Hexham Long Term Train Stabling Facility Modification 2 (SSI-6090-Mod-2) – Project Amendment

The purpose of this submission is to request that the scope of the modification to the approved State Significant Infrastructure Project for the Hexham Long Term Train Support Facility (LTTSF Project) (SSI-6090 – Mod 2) be amended prior to finalisation of the assessment. This modification is for the development of a depot, warehouse and wagon storage (the Modification Proposal) at the LTTSF, and has been submitted under Section 5.25 of the *Environmental Planning and Assessment Act 1979* (EP&A Act).

This Project Amendment has been prepared by Ethos Urban, on behalf of Aurizon, and is accompanied by Revised Modification plans provided in **Attachment A**, and a revised Landscaping Plan provided at **Attachment B**.

WAREHOUSE - ELEVATIONS

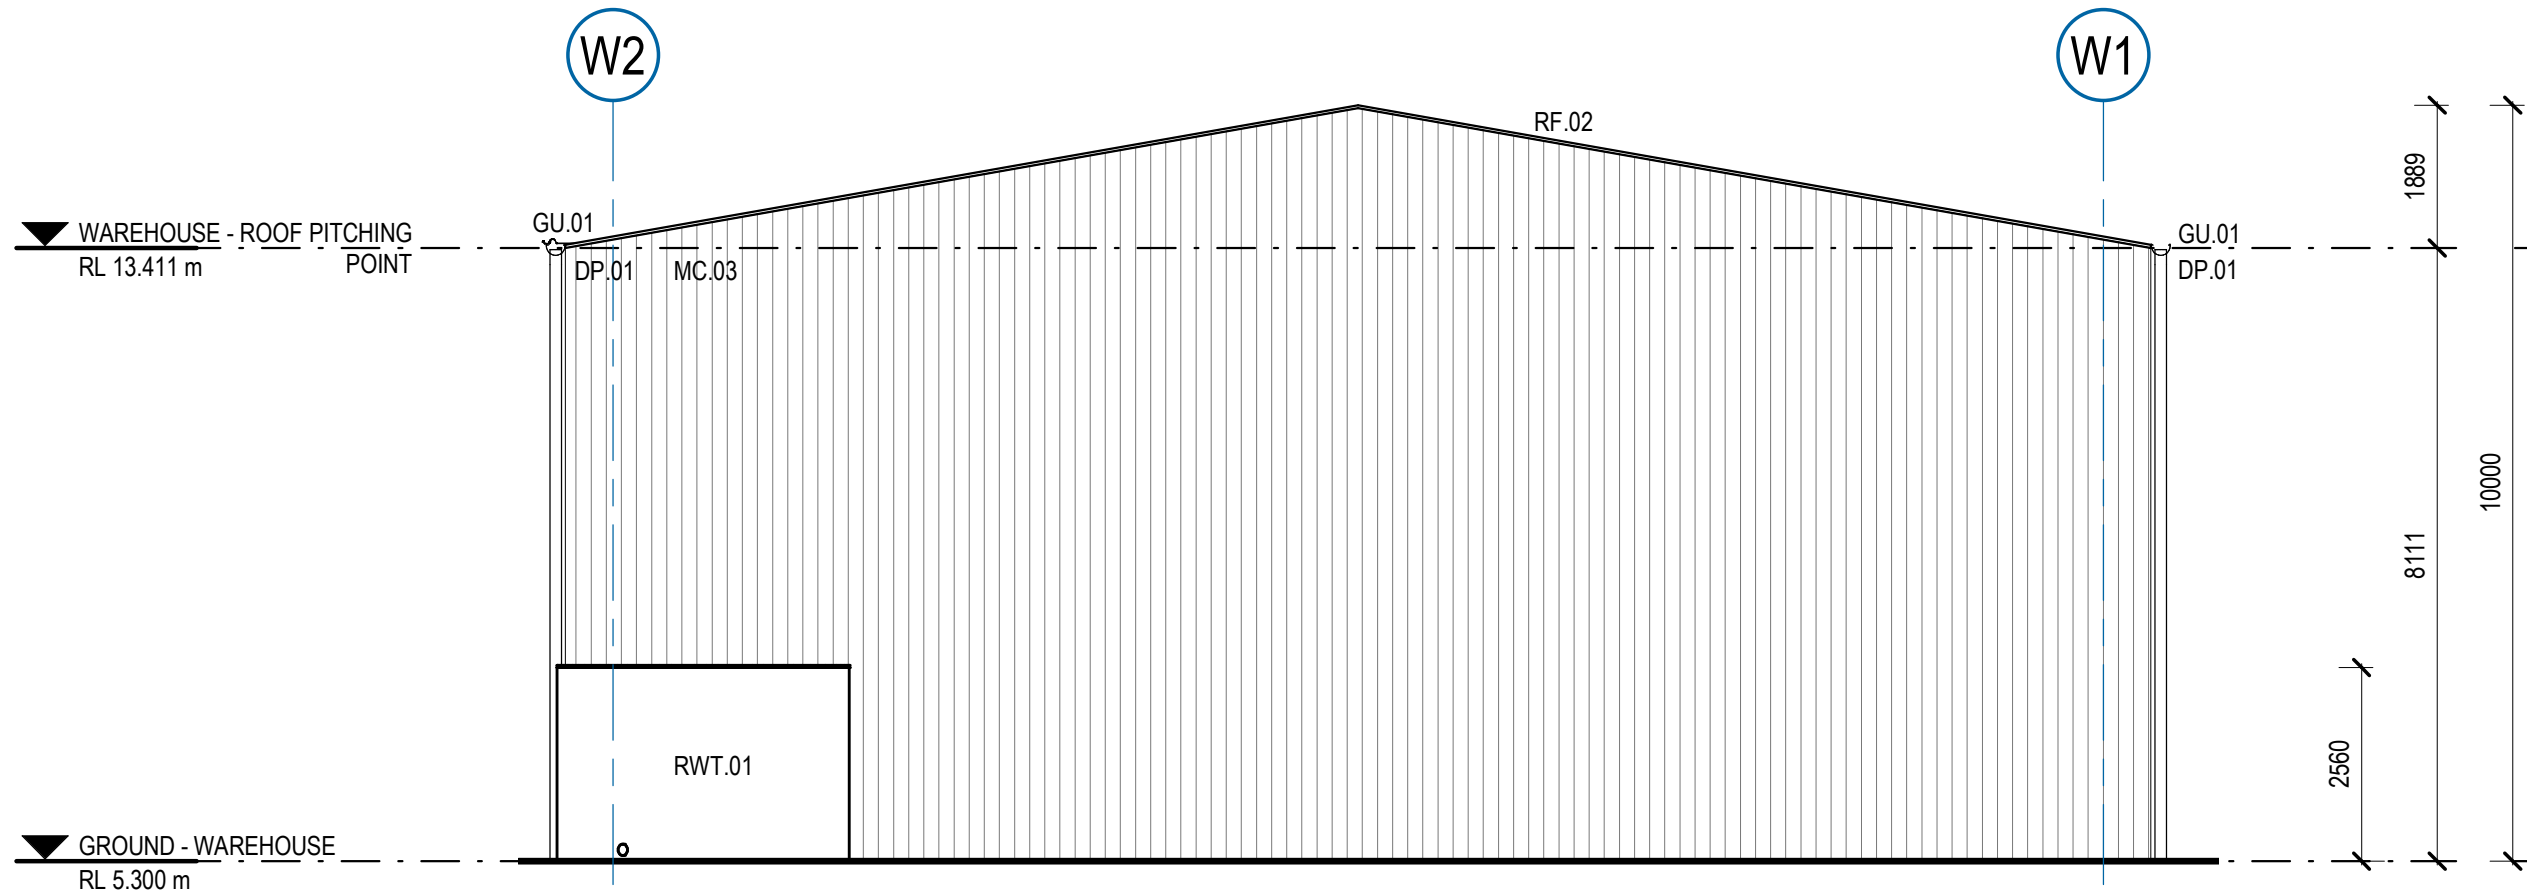
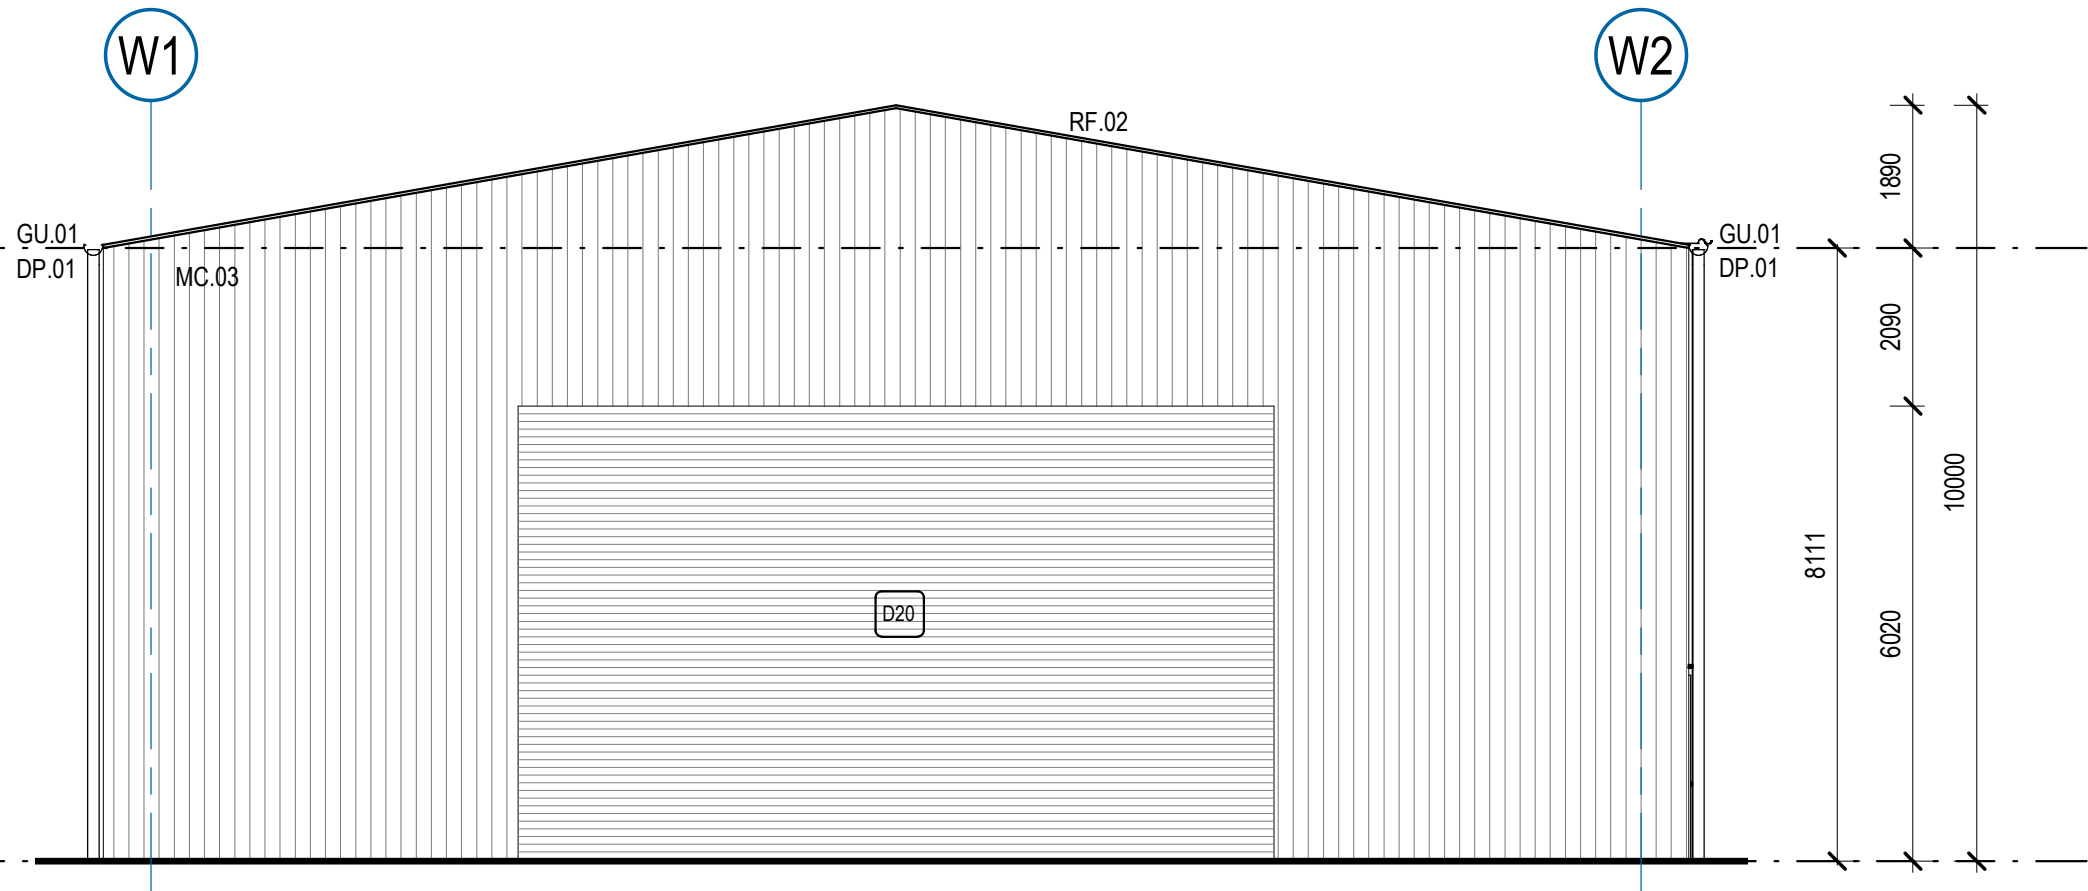
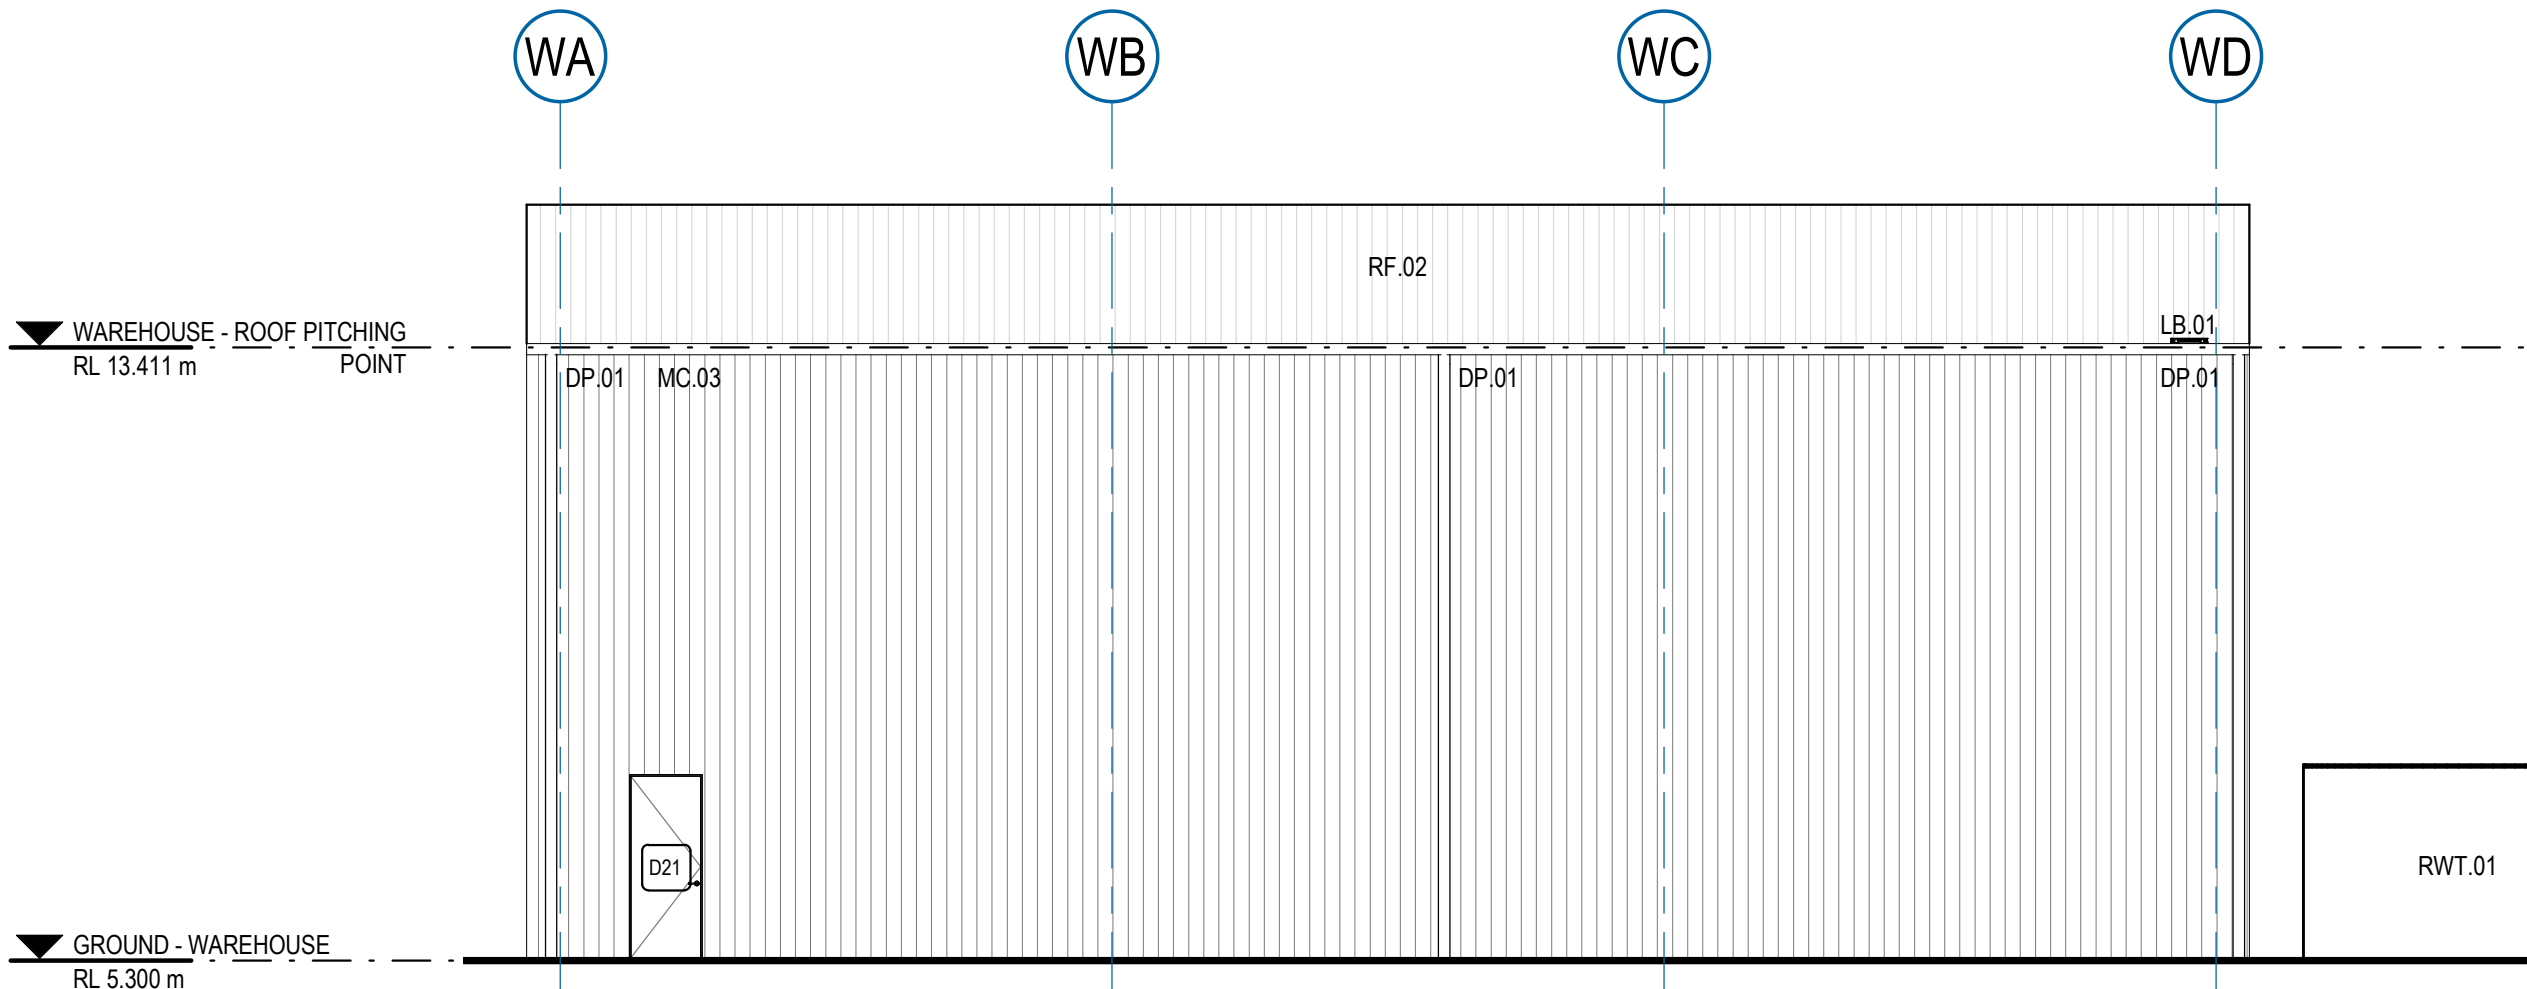
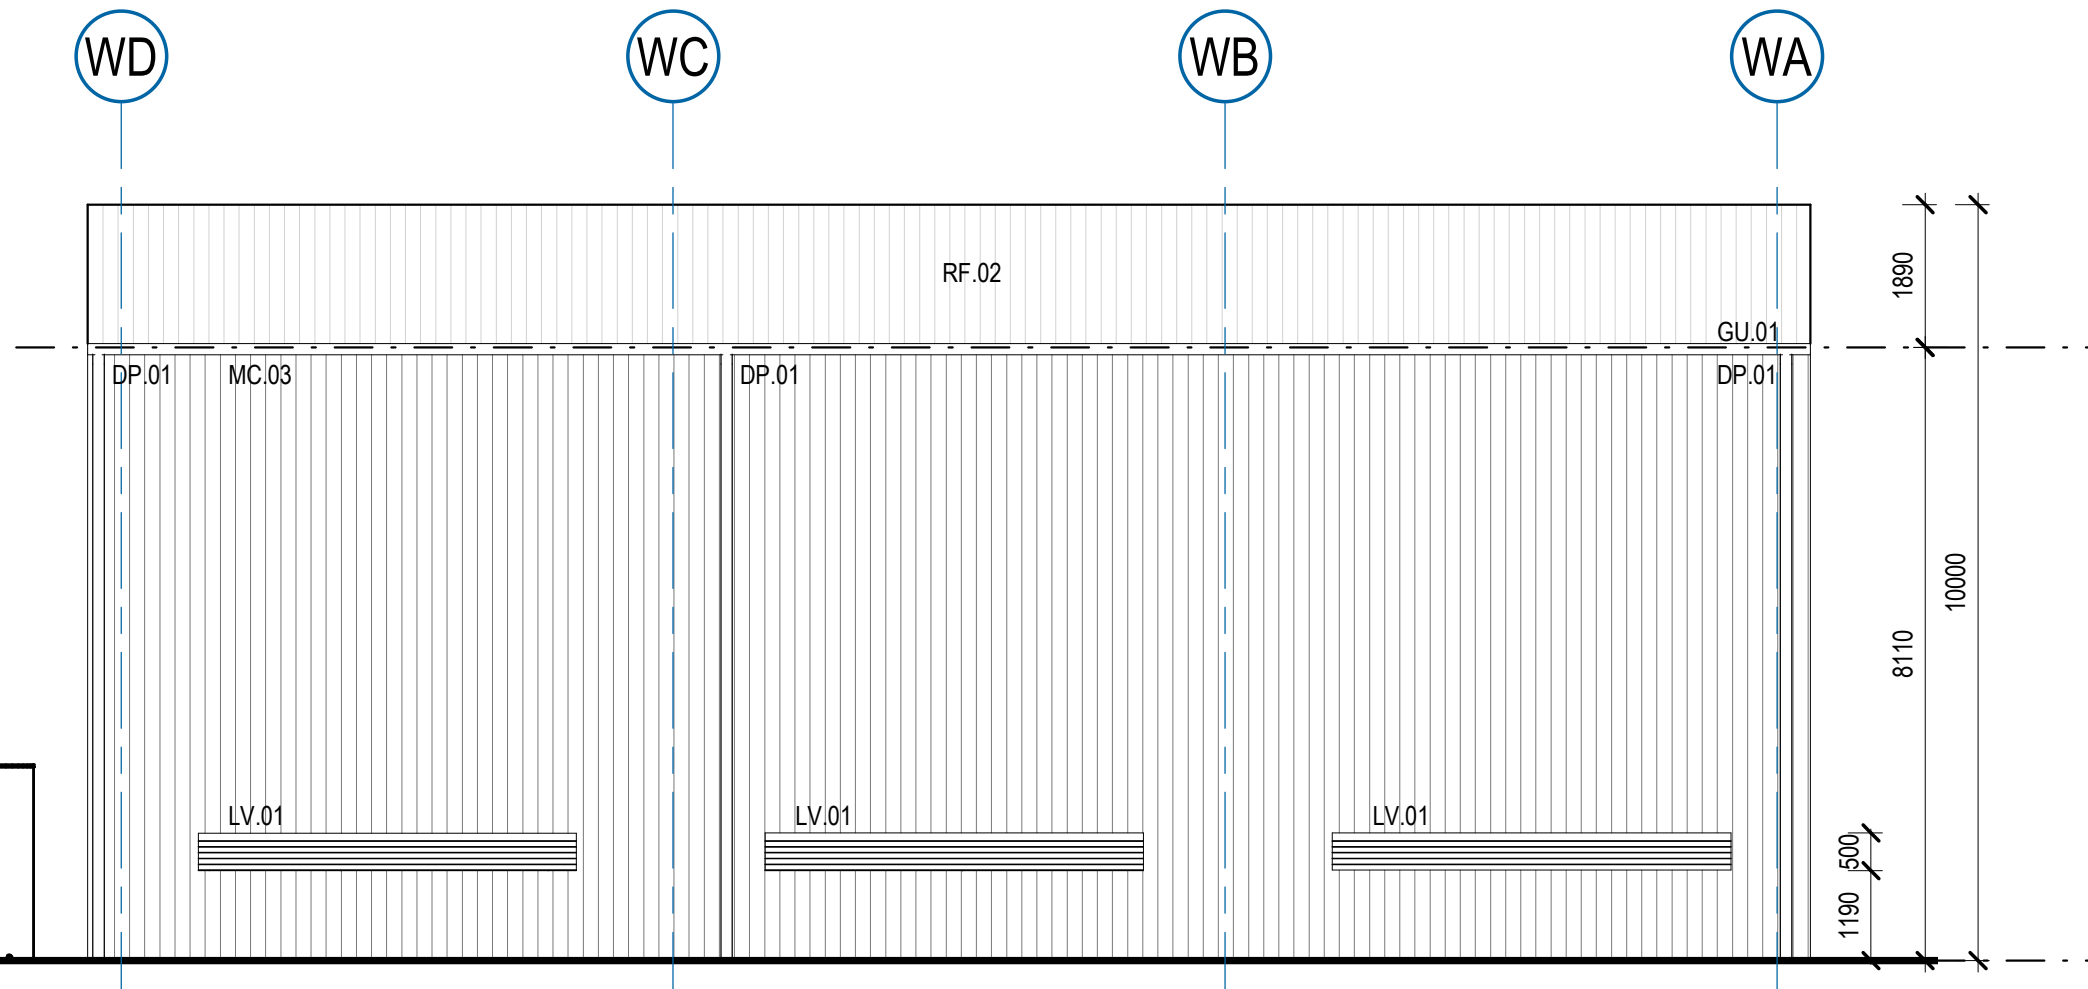
- The warehouse will be reduced in height from 12.3m to 10m. Changes to the materials and finishes, although the warehouse will still be finished predominantly in colourbond steel. .
